# Abergelli Power Project

Areas of Agreement between Abergelli Power  
Limited with Natural Resources Wales

Statement of Common Ground

09 November 2018

Figure 1 – Phase 1 Habitat Map

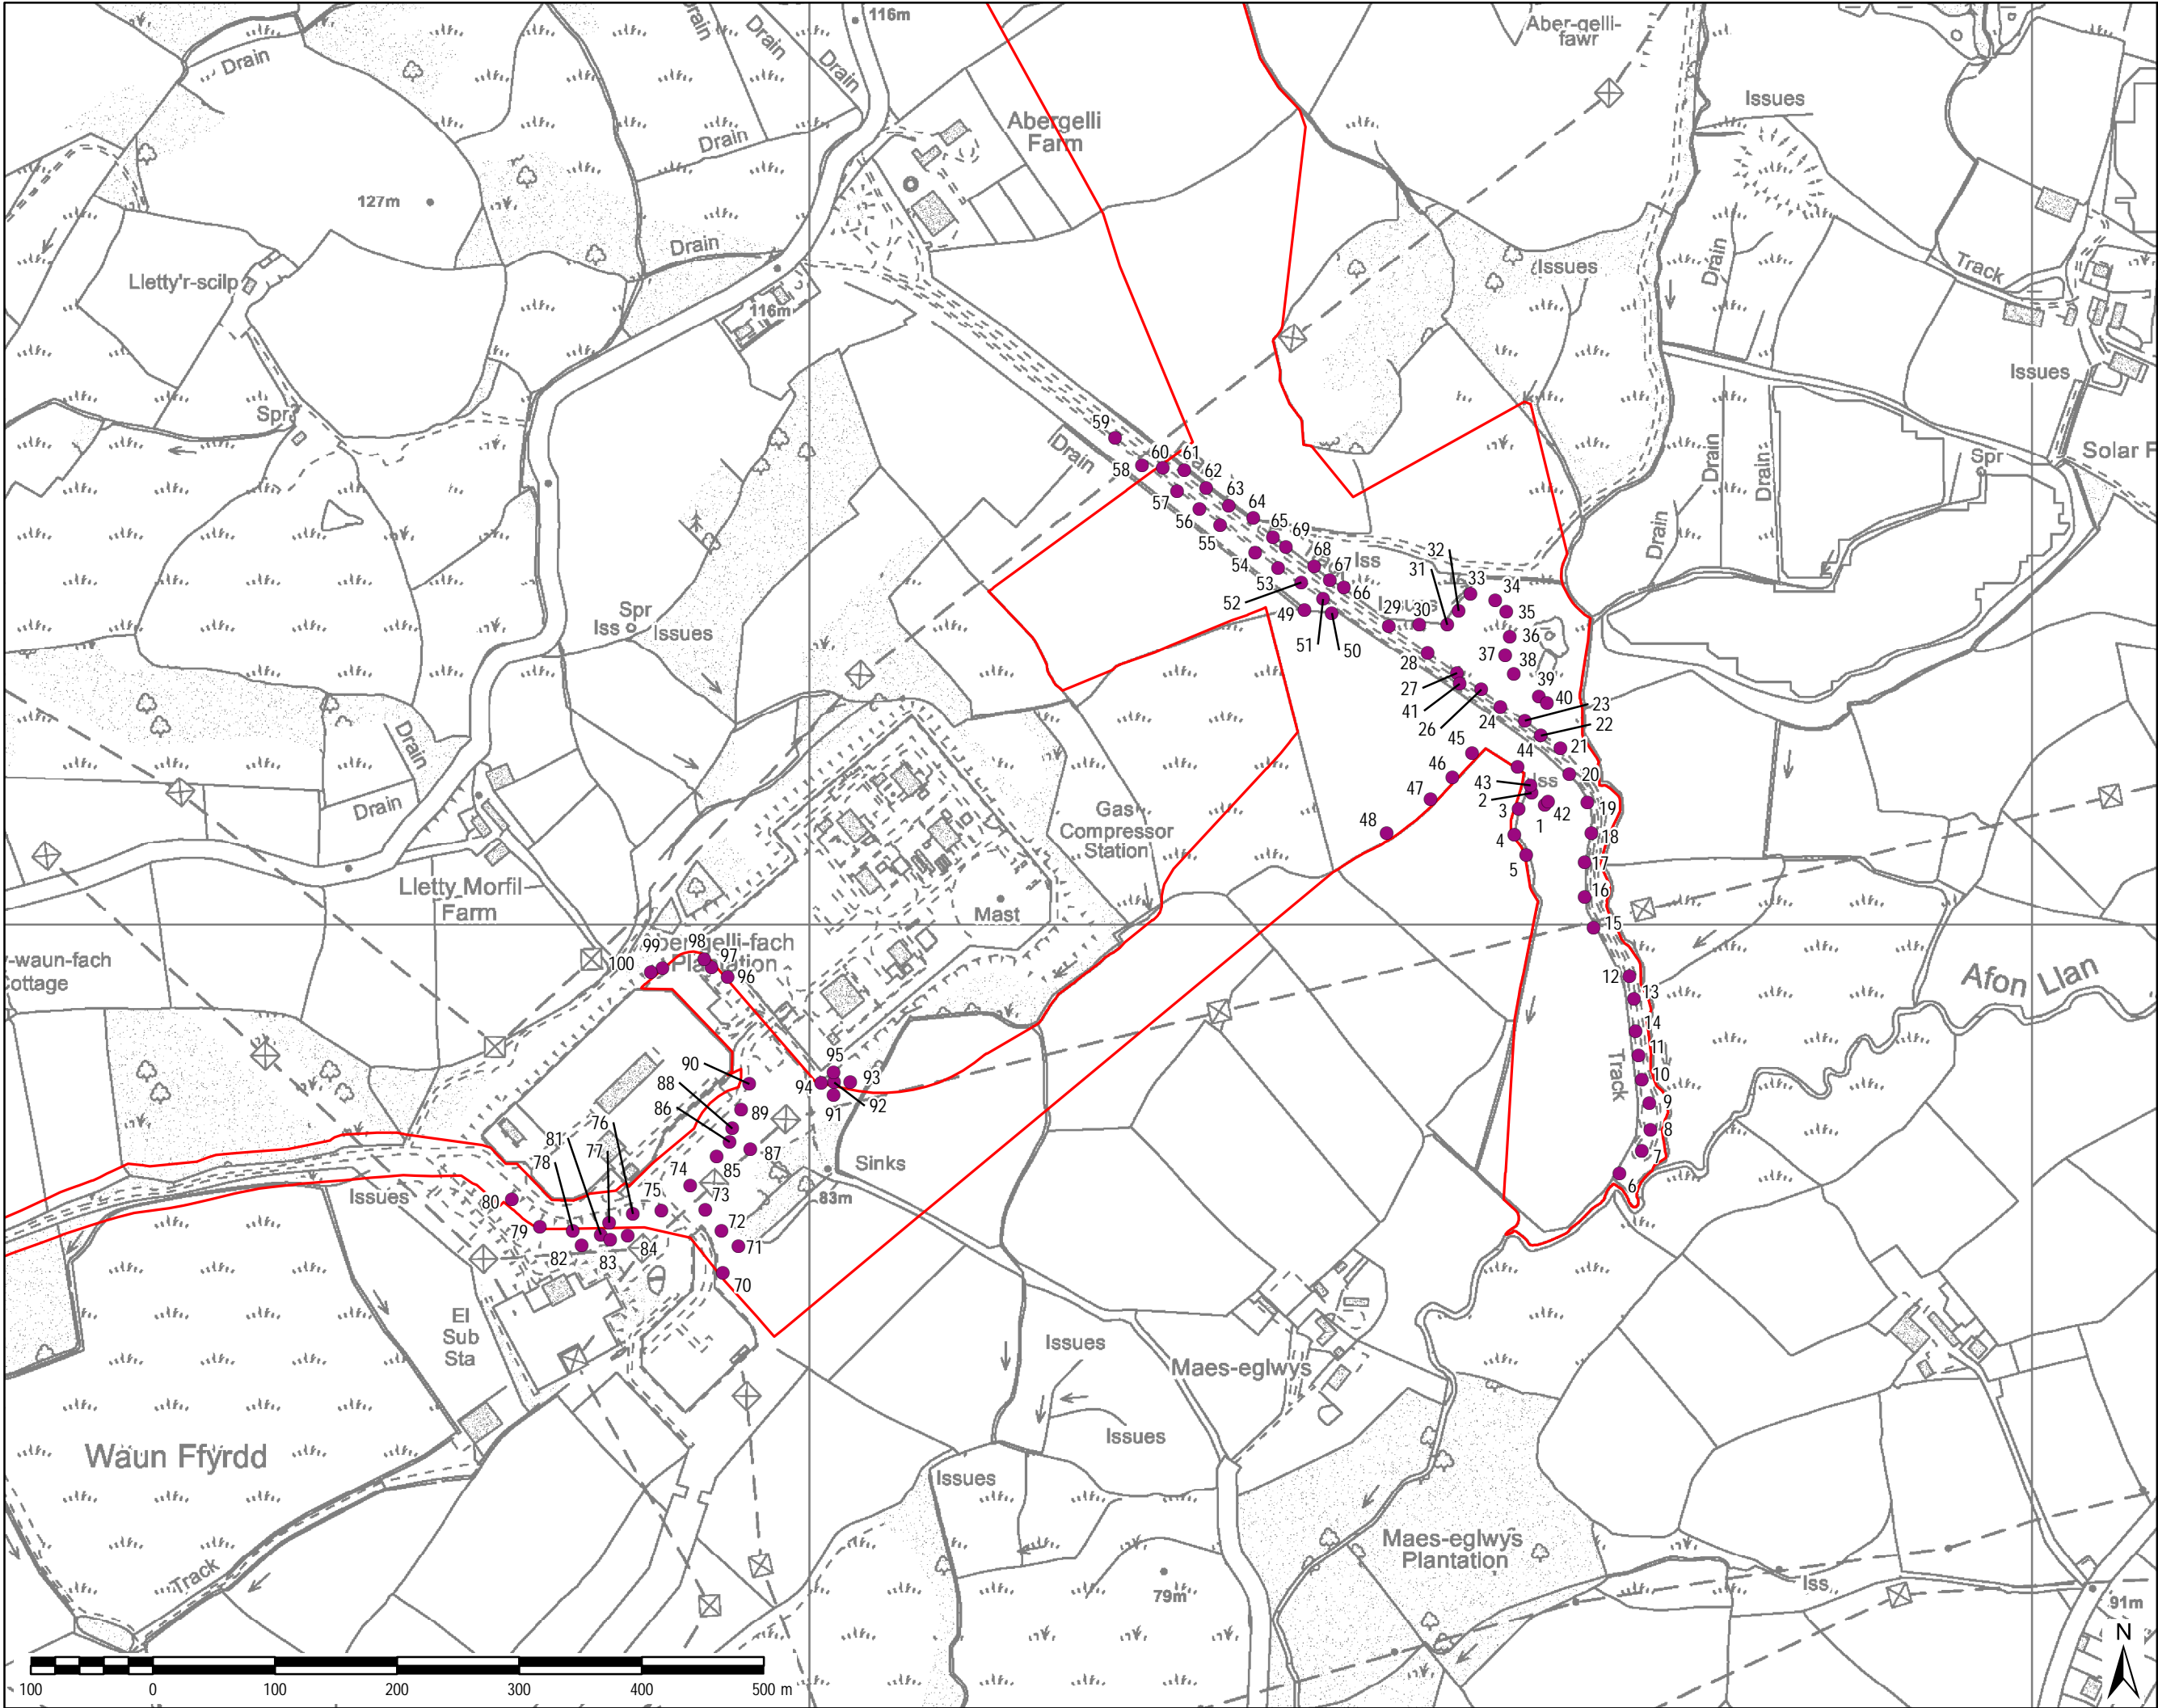
ID	Statement on which APL seeks agreement	APL	NRW
			<p>proposals as above.</p> <p>Appendix D makes reference to Figure 1. Can you clarify if this should be Figure 1.1?</p>
3.F.11	<p><i>Mitigation</i> – ██████</p> <p>Both parties AGREE to the mitigation methods provided in Appendix E of the LEMS.</p>	Noted	<p>Comments on mitigation does not fall under NRW's remit. We refer you to the Local Planning Authority (LPA) for comments on this matter. NRW licensing department are however responsible for issuing any ██████ licences required.</p>
3.F.12	<p><i>Mitigation</i> - Invasive Species</p> <p>Both parties AGREE to the mitigation methods provided in Appendix F of the LEMS.</p>	Noted	<p>This does not fall under NRW's remit. We refer you to the Local Planning Authority</p>
